Re: Interference with Prescriptive Easement and Unlawful Obstruction

This firm represents Chris and Nicole Niederman, your neighbors to the south. The Niedermans own the property located at 6800 96th Ave. SE, Mercer Island, WA 98040. This letter concerns your pending building permit application, MI Project Number 1902-005. As you know, in addition to your property, the Niedermans and the four abutting property owners to the west all utilize a private access road/utility easement located between SE 68th St. and SE 67th St. for ingress and egress to their properties. The access road/easement is expressly identified on the face of the City subdivision approval.

SITE PLAN
6660 MERCER WAY
Mercer Is., WA 98040
SCALE: 1/8" = 1'-0"

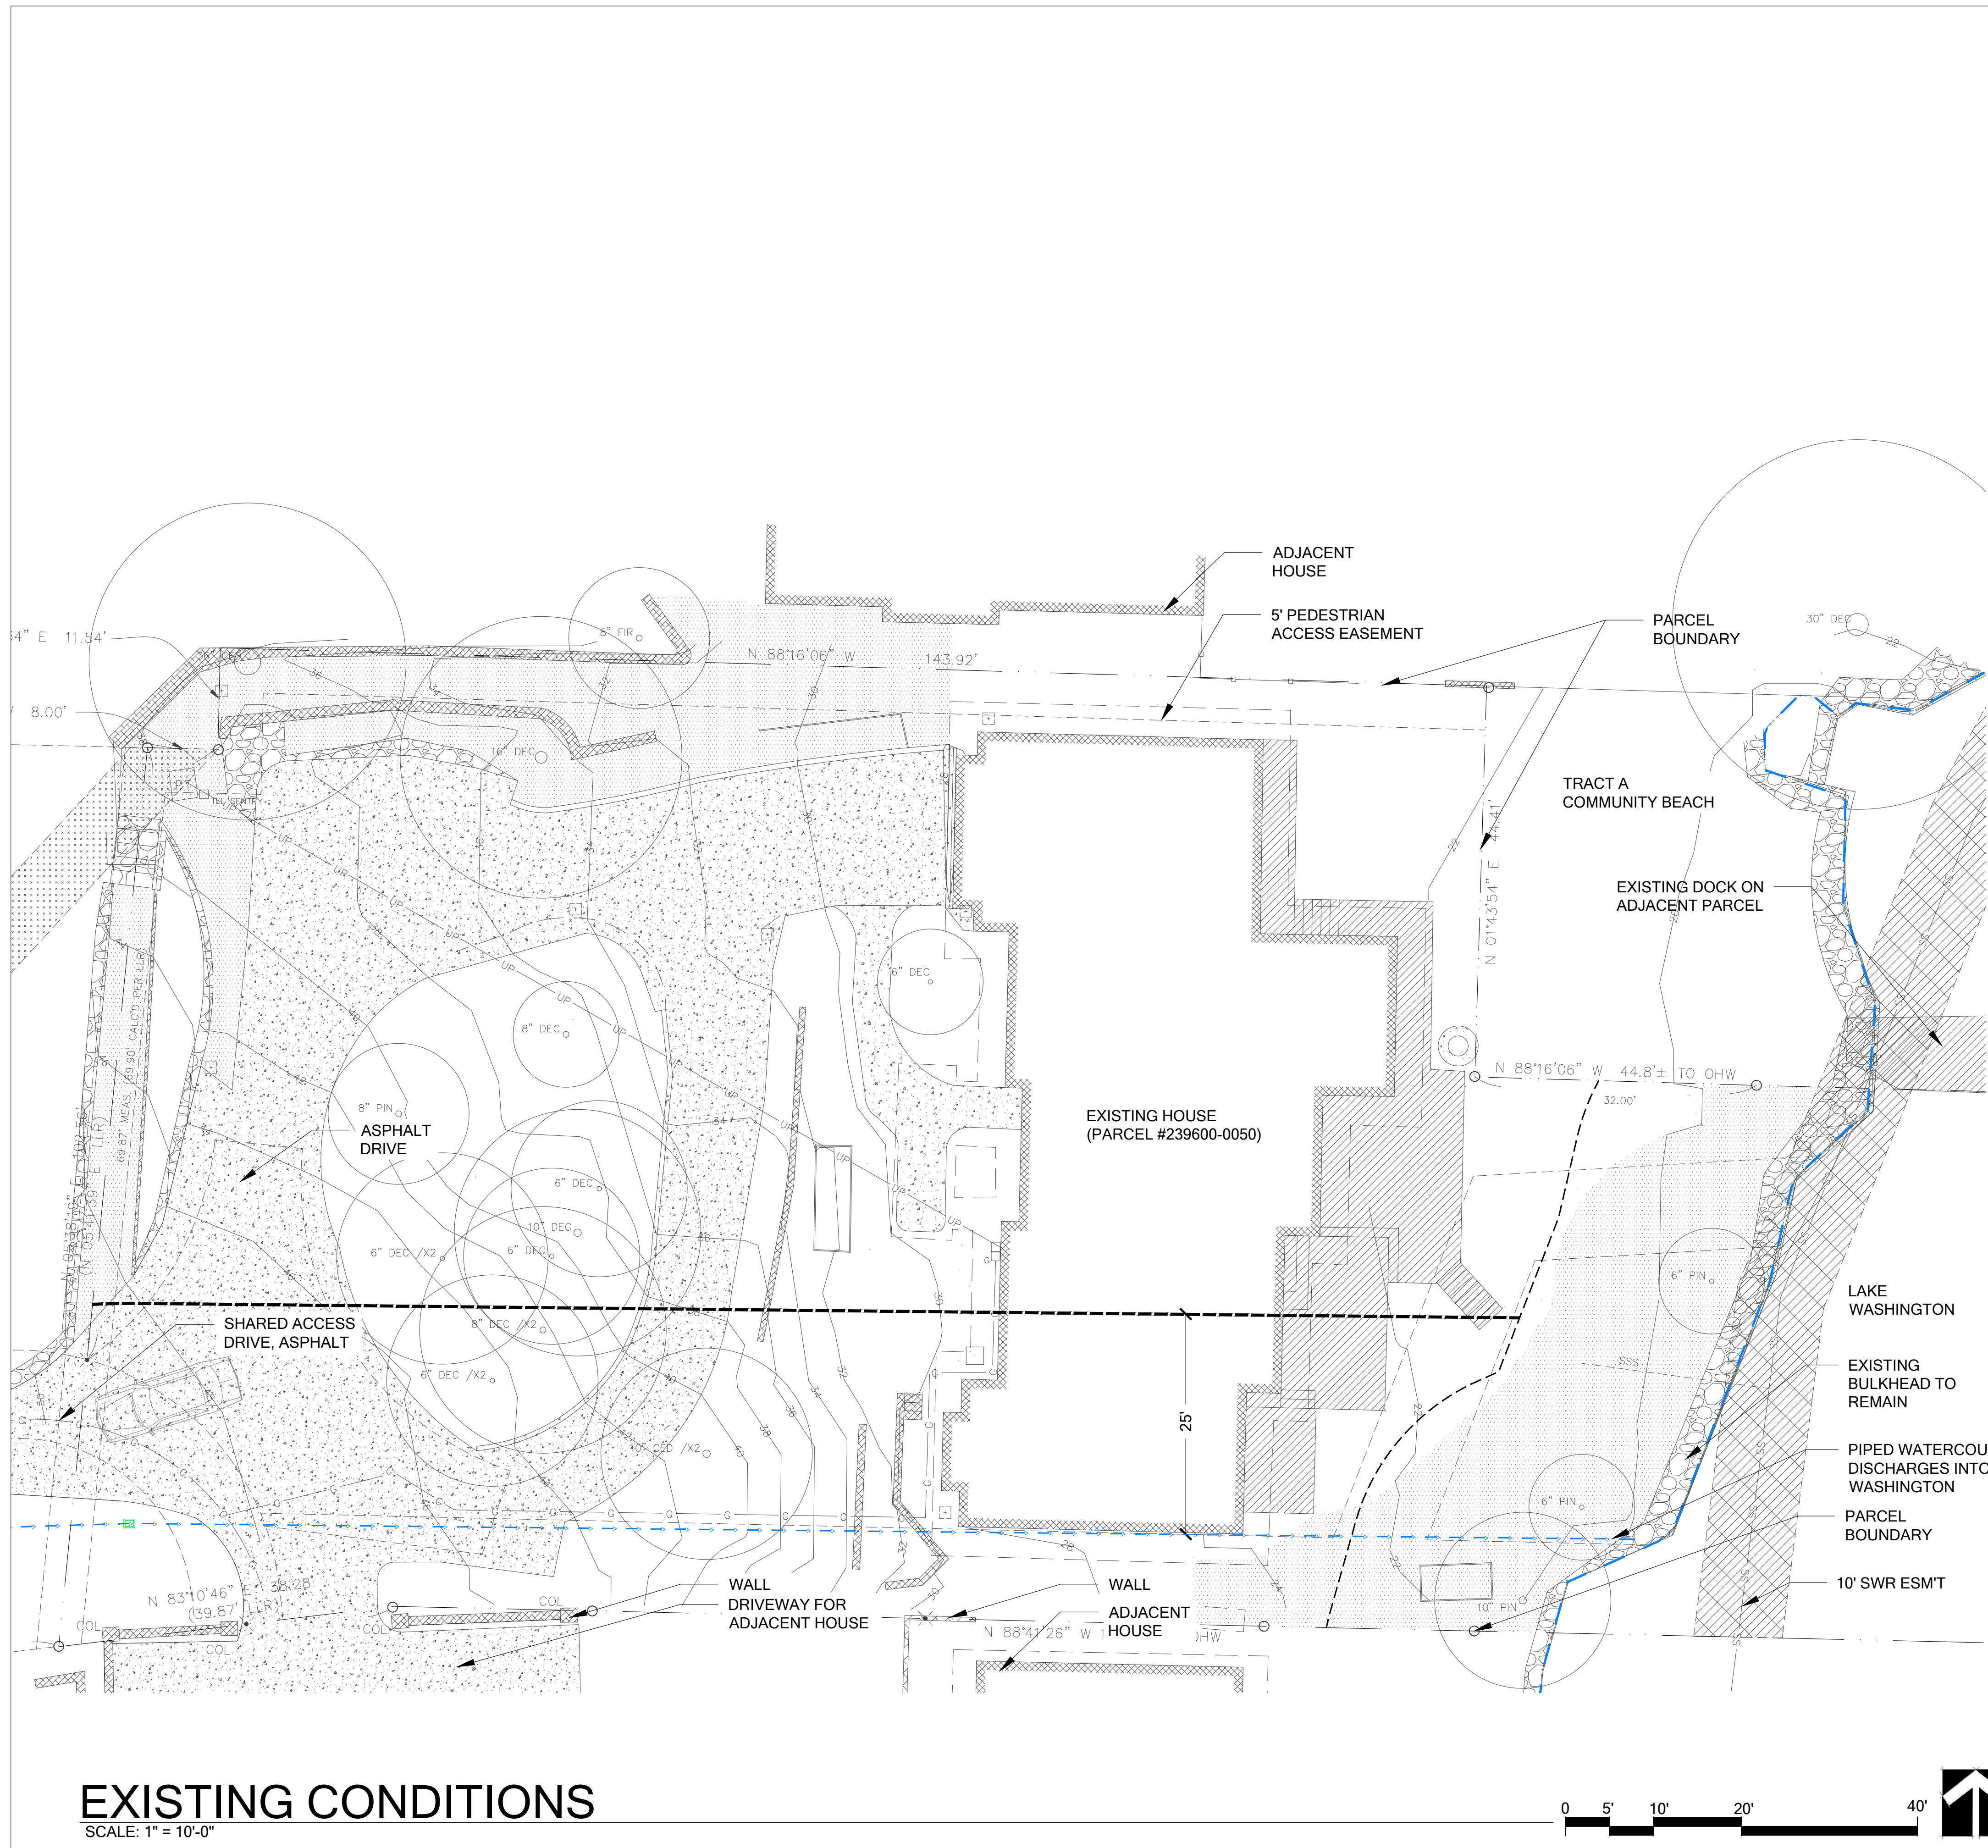
Based on your construction plans, we understand you intend to alter the shared access road on the southwestern corner of your property so it will no longer align with the Niedermans' existing driveway. See **Attachment A**. We write to insist you marginally alter your construction plans to maintain the current location of the shared access road so it continues to align with the Niedermans' driveway access.

Developing your property in a way that prevents the Niedermans from accessing their driveway will subject you to liability for unlawful obstruction and interference with the Niedermans’ easement. We expect you will alter your construction plans to maintain the current location of the shared access road so that it continues to align with the Niedermans’ driveway access. If you do not make this alteration and move forward with your current construction plans, the Niedermans will be forced to take legal action to (1) establish their prescriptive easement as a matter of law; and (2) obtain an injunction preventing you from obstructing and/or interfering with their continued use of the easement.
